Fosse Green Energy

EN010154

8.6 Statement of Common Ground with the Lincolnshire Wildlife Trust

24 March 2026

Figure 8-5

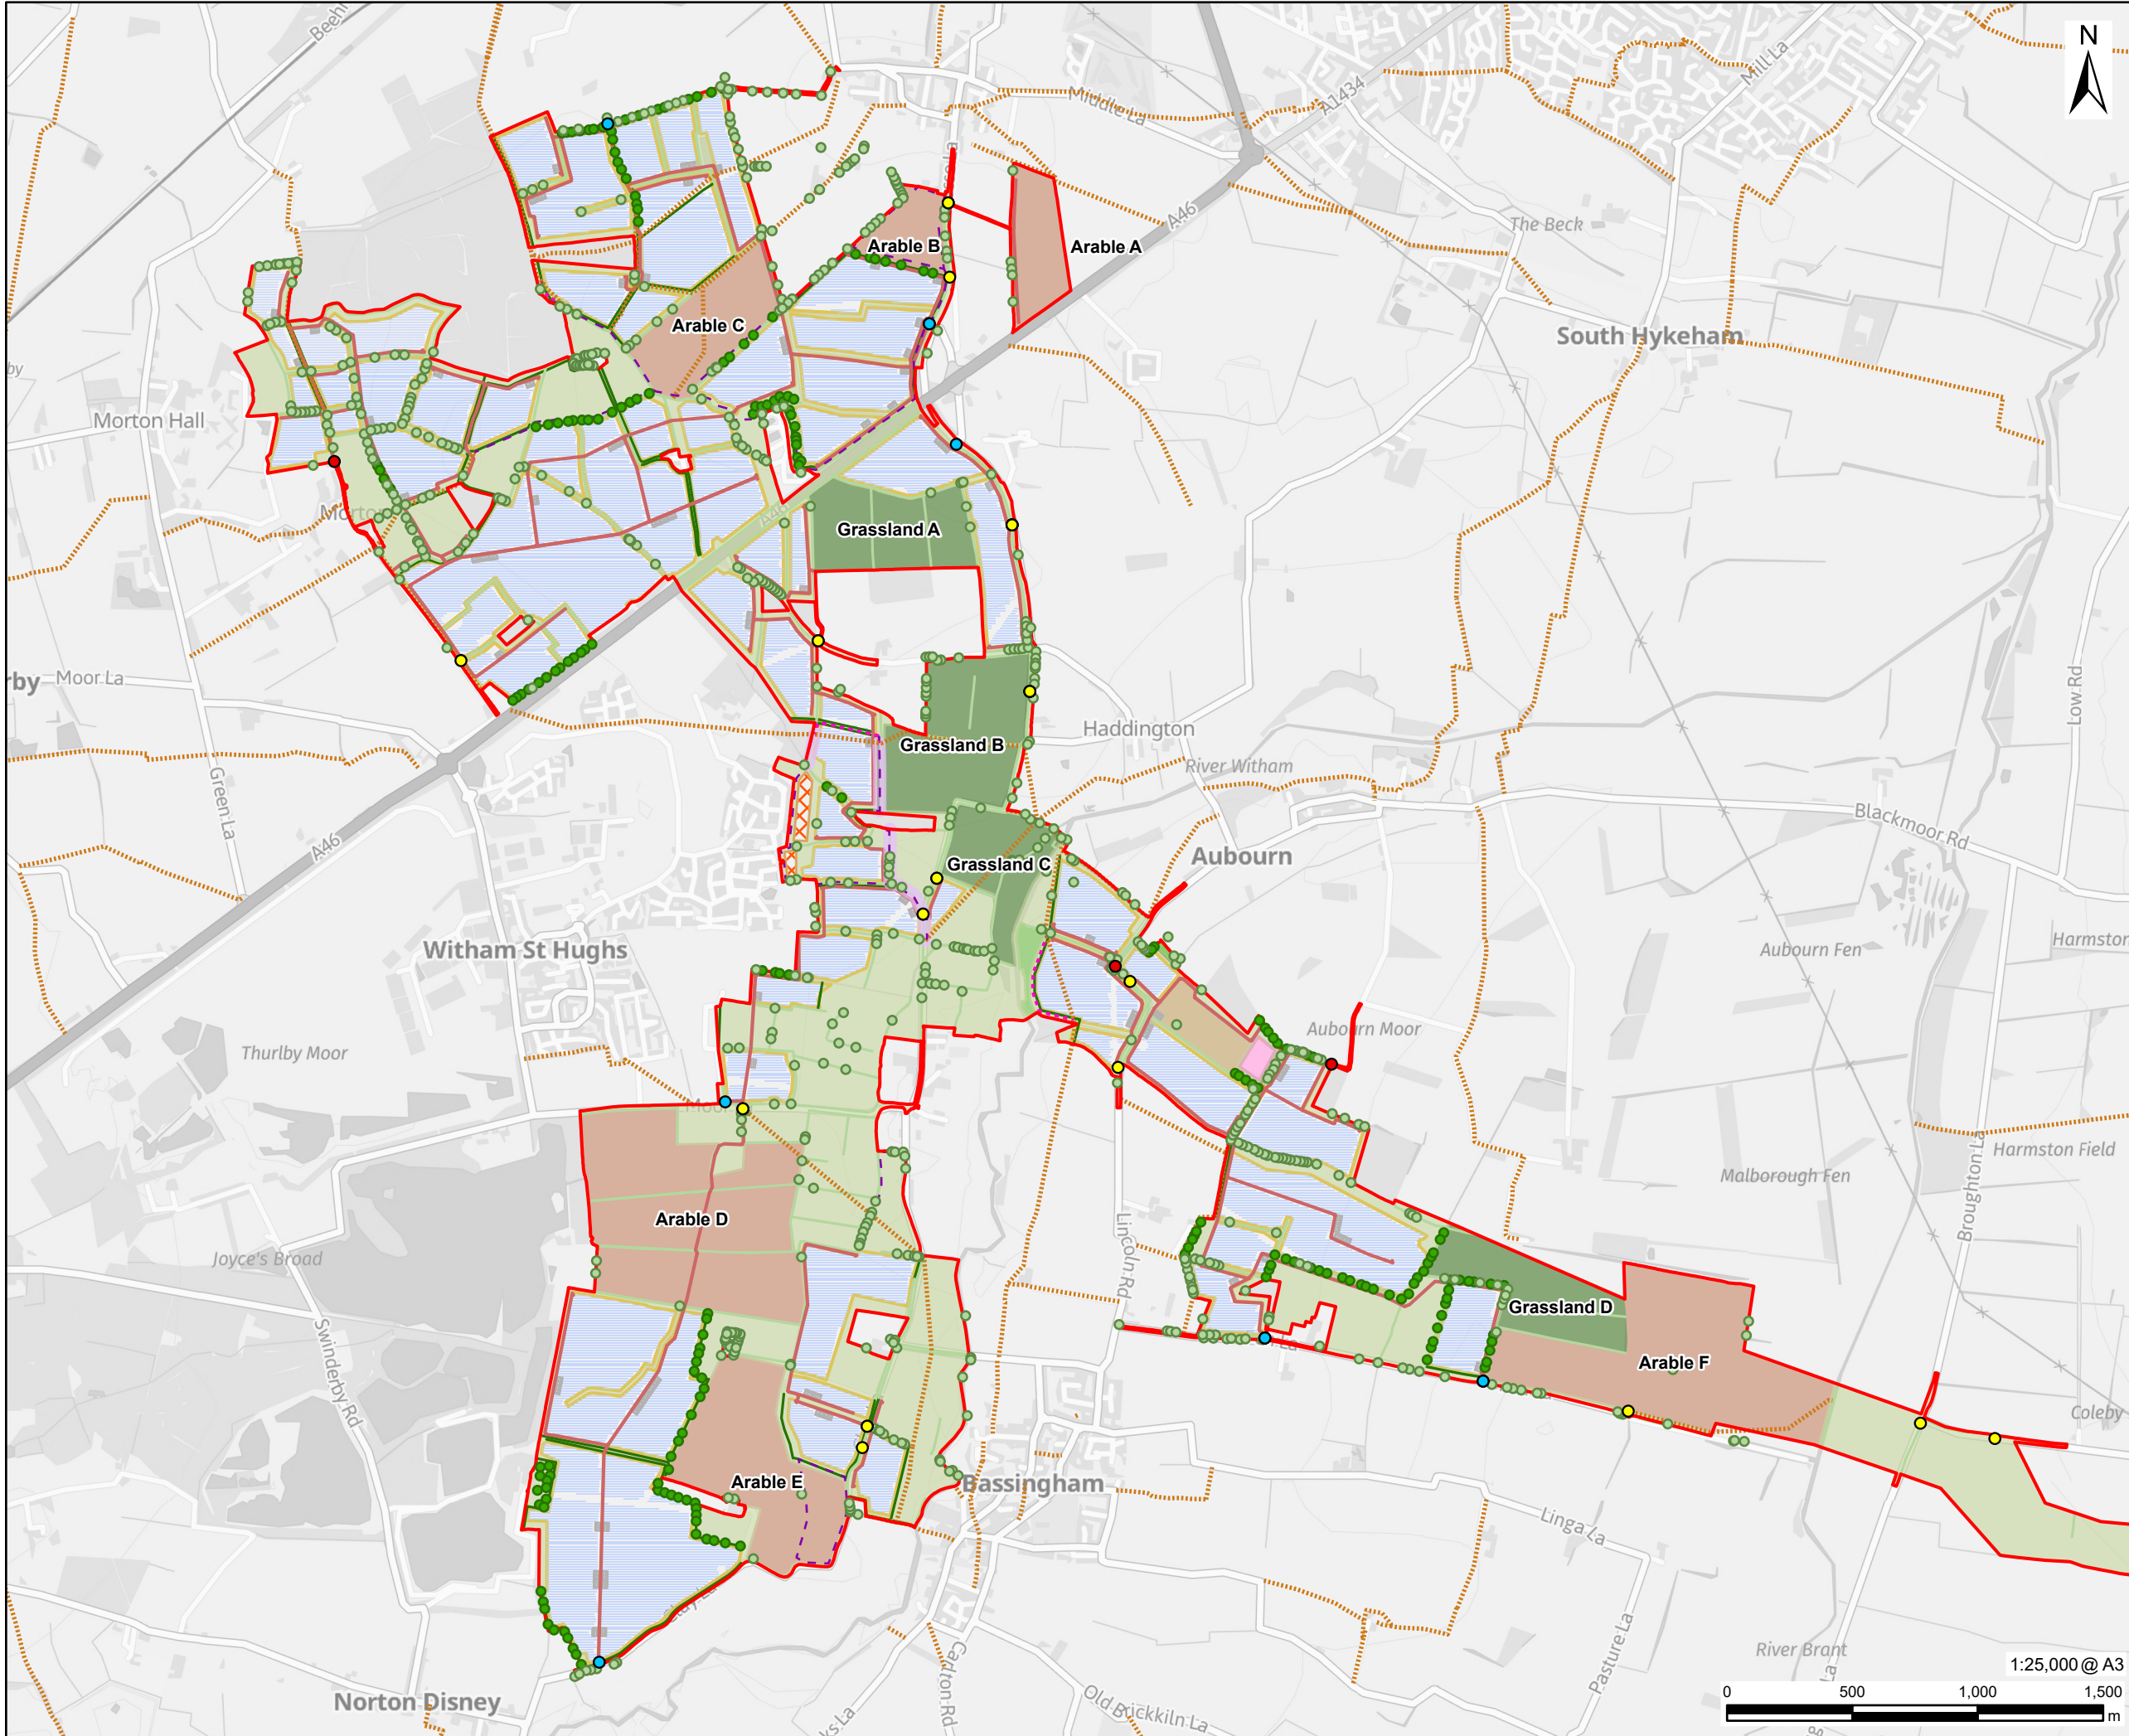
4.1.6	<p>Impacts on ground nesting birds (including cumulative impacts)</p>	<p>Concern regarding impacts on ground nesting birds. Lincolnshire Wildlife Trust recommend that all grassland areas are utilised but are satisfied that a minimum of 64 hectares of grassland will be provided for mitigation.</p>	<p>The mitigation relating to ground nesting birds can be found in the Framework Landscape and Ecological Management Plan (LEMP) [REP2-021] which states in Section 5.2, "<i>Managed arable land would be provided within the areas of the DCO Site where there is no solar PV infrastructure to benefit ground nesting birds. These areas are indicatively illustrated as Arable fields A to F on Figure 8-5 Bird Mitigation Land Allocation of the ES [APP-081]. These would provide habitat for important ground nesting birds such as Skylark and Lapwing</i>".</p> <p>Further detail on the proposed mitigation relating to ground nesting birds is detailed in the revised Framework LEMP and the Applicant's Responses to IP Deadline 2</p>	Agreed
